Engineers Comments Regarding Surface Water Drainage

Application Reference:	R/239/24/PL	Reviewer Reference:	ADC/SB
Planning Officer:	Harry Chalk	Date of Review:	06/08/2025
Site Name:	Condair Building Artex Avenue Rustington BN16 3LN		
Application Description:	Demolition of existing building (facing Brookside Avenue) and redevelopment of the rear of the site for office use, with ancillary storage facilities and landscaping falling within Class E. This application is in CIL Zone 4 and is zero rated as other development.		
Assessment Number:	2 of 2

Drawing Title
Proposed Drainage Strategy

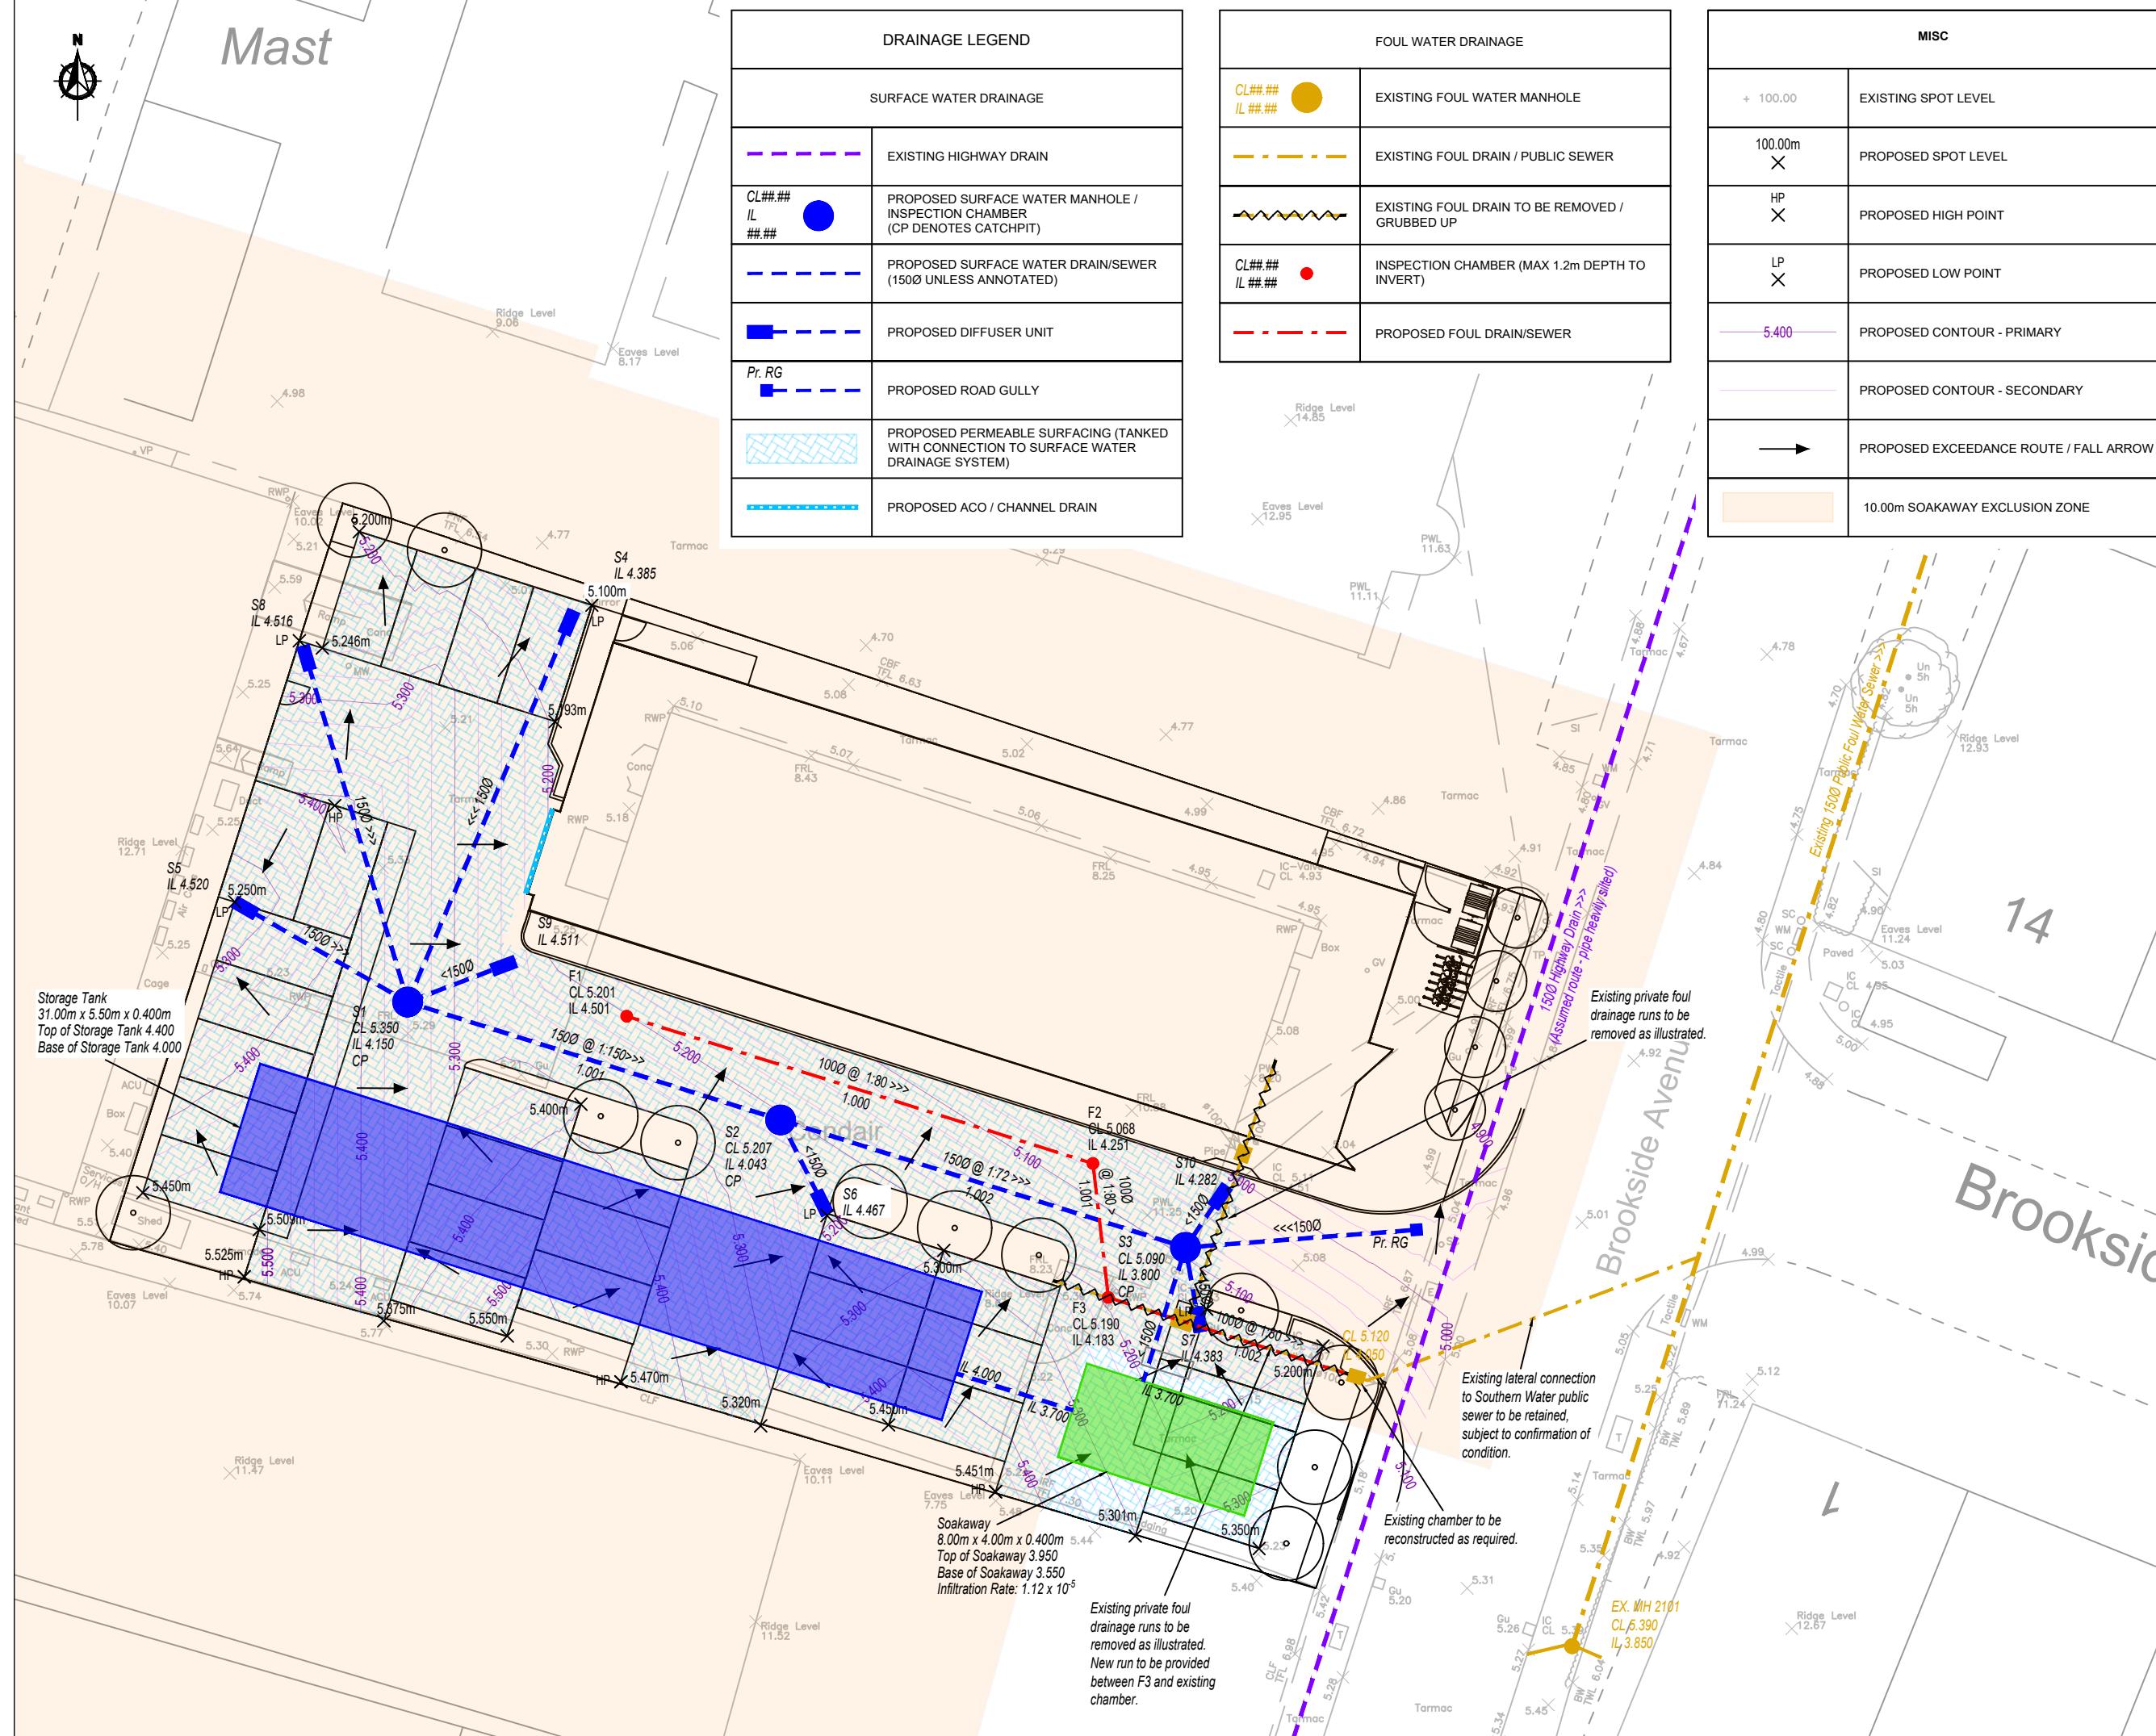
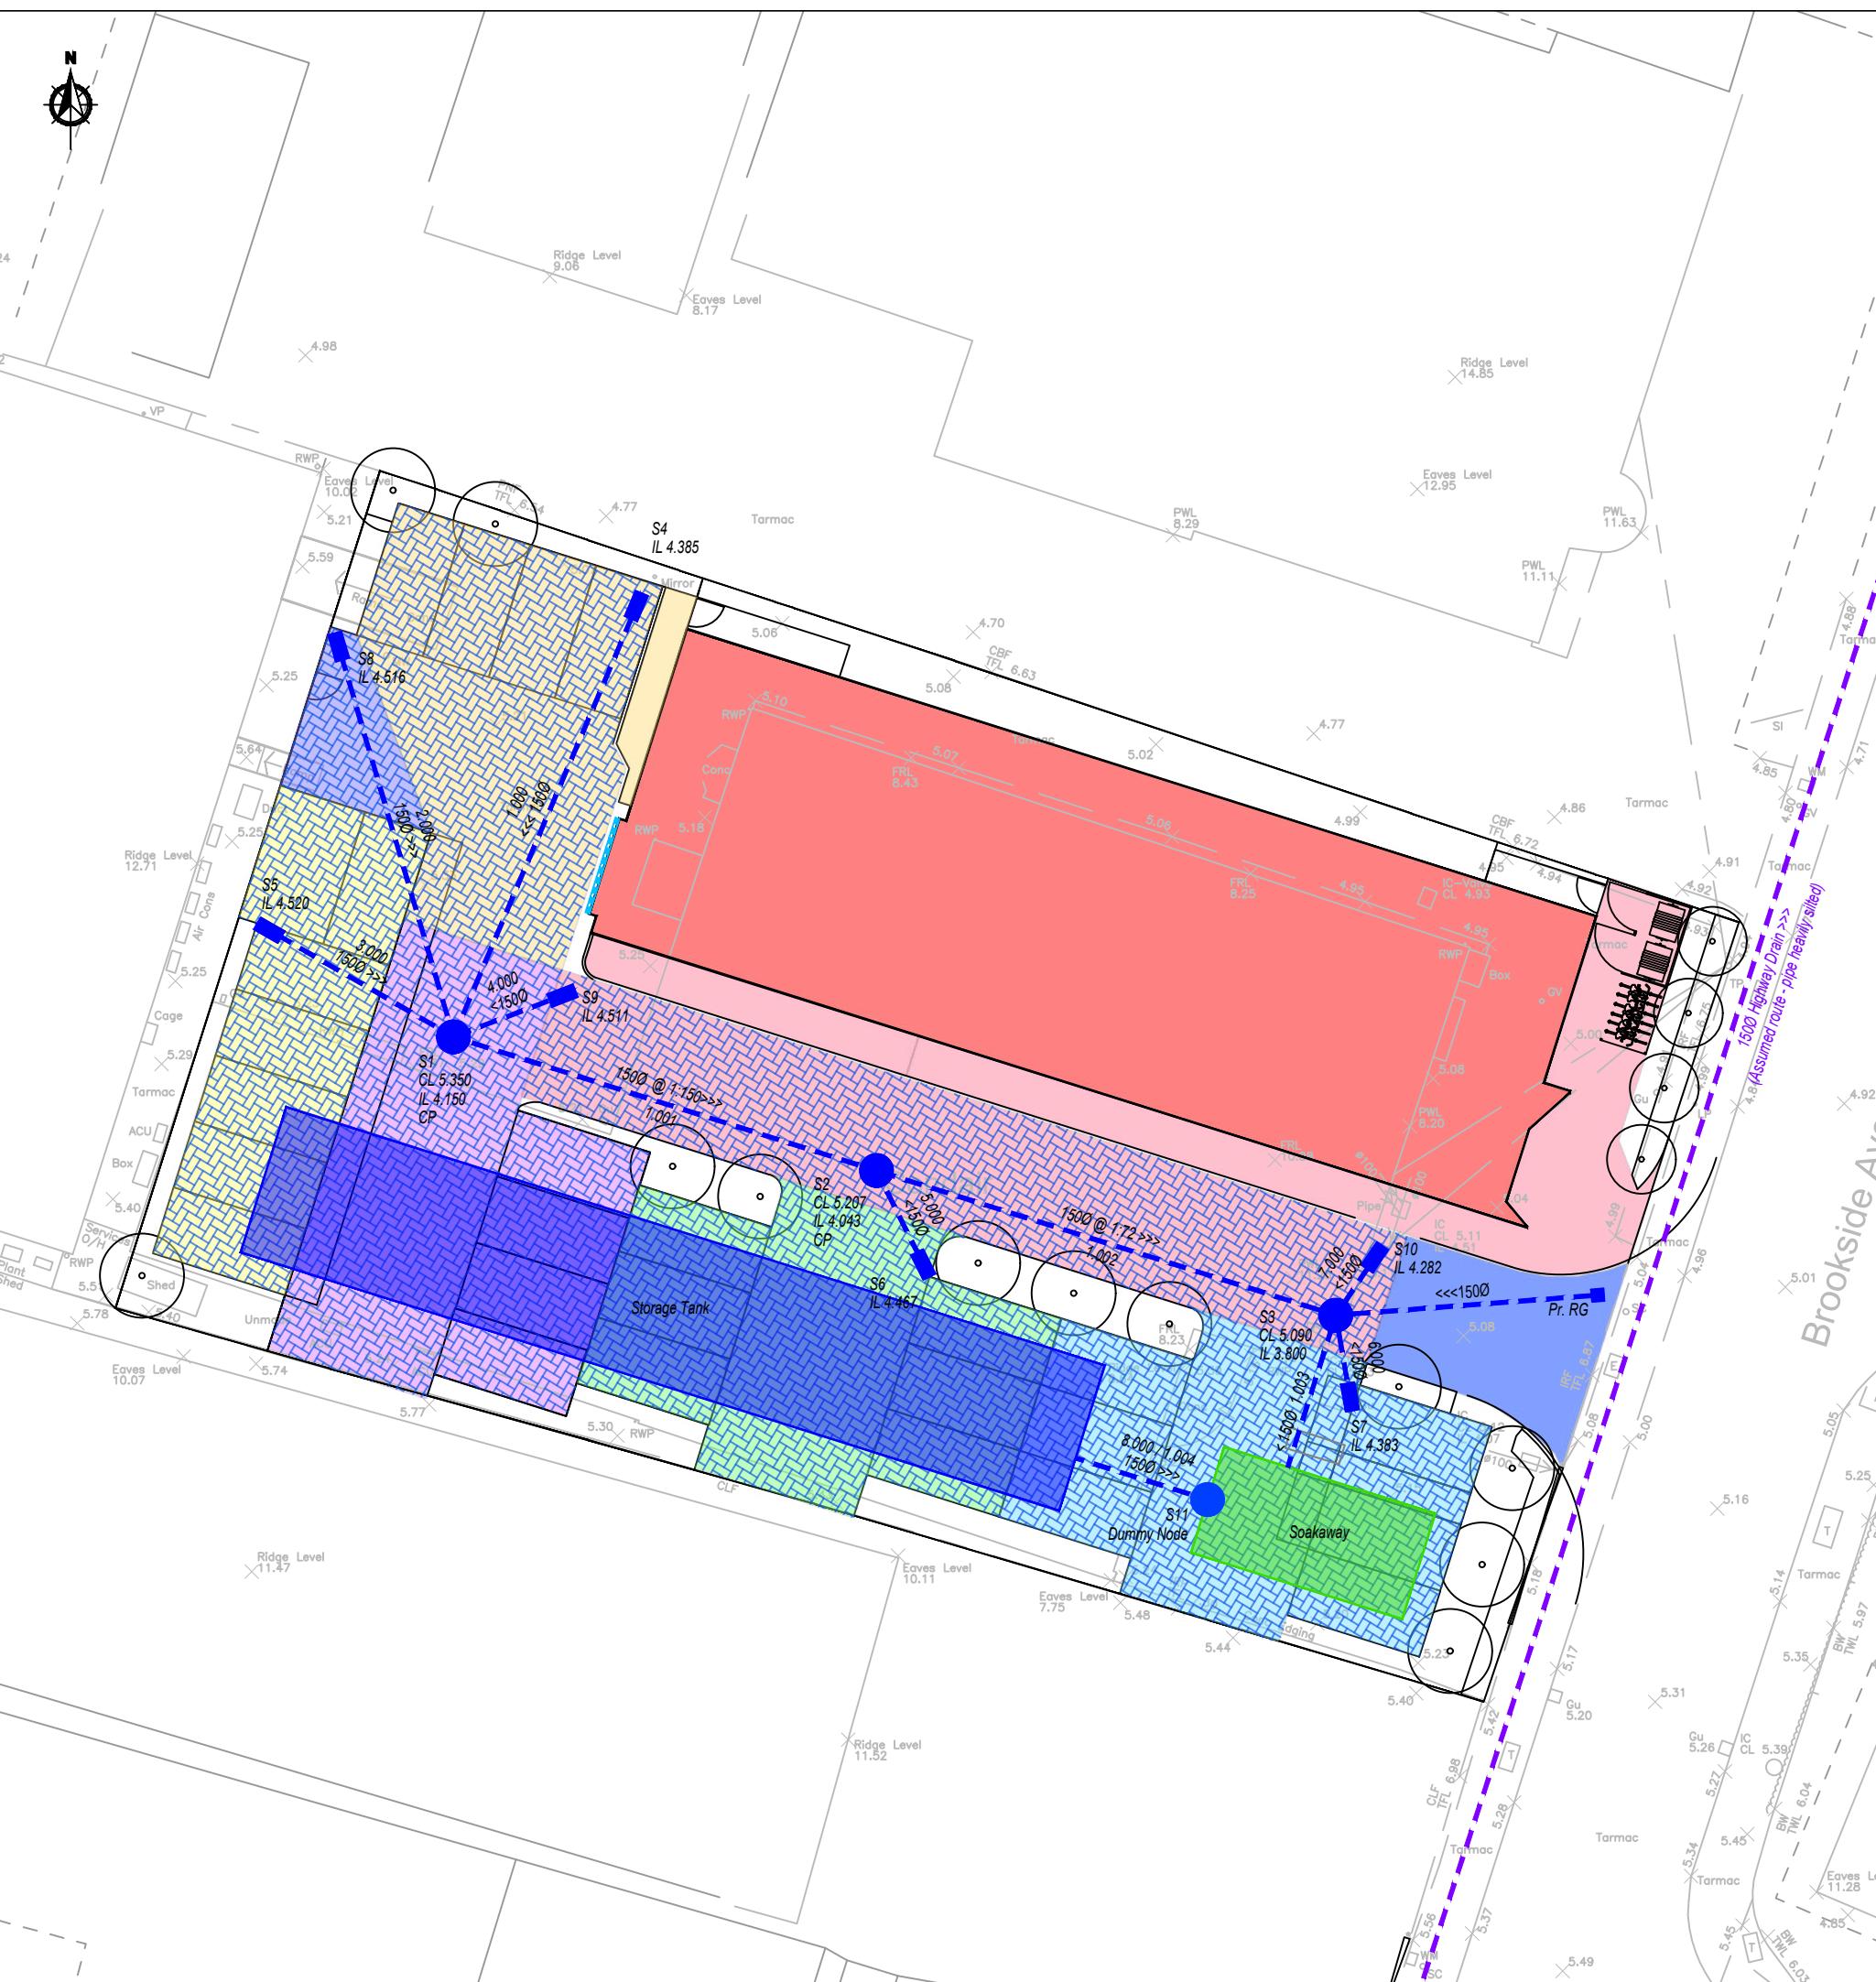
Comment Number					
1.	The design does not correspond with the infiltration test that was completed as the soakaway is 0.4m deep and the depth of pit soaked in the test was 1.12m. The base of the soakaway is also deeper than the test. Acceptable for this stage of the planning process but not for detailed design for approval via condition.

2.	It is unclear what node S11 relates to, it looks like it should be a node between the soakaway and the tank but one isn't shown.				
3.	The incoming pipe invert level is above the 1 in 10 year water depth in the soakaway, the pipe must be raised if possible.

4.	Construction details to be provided for all components.				
5.	Further detail required on the plans – see checklist.
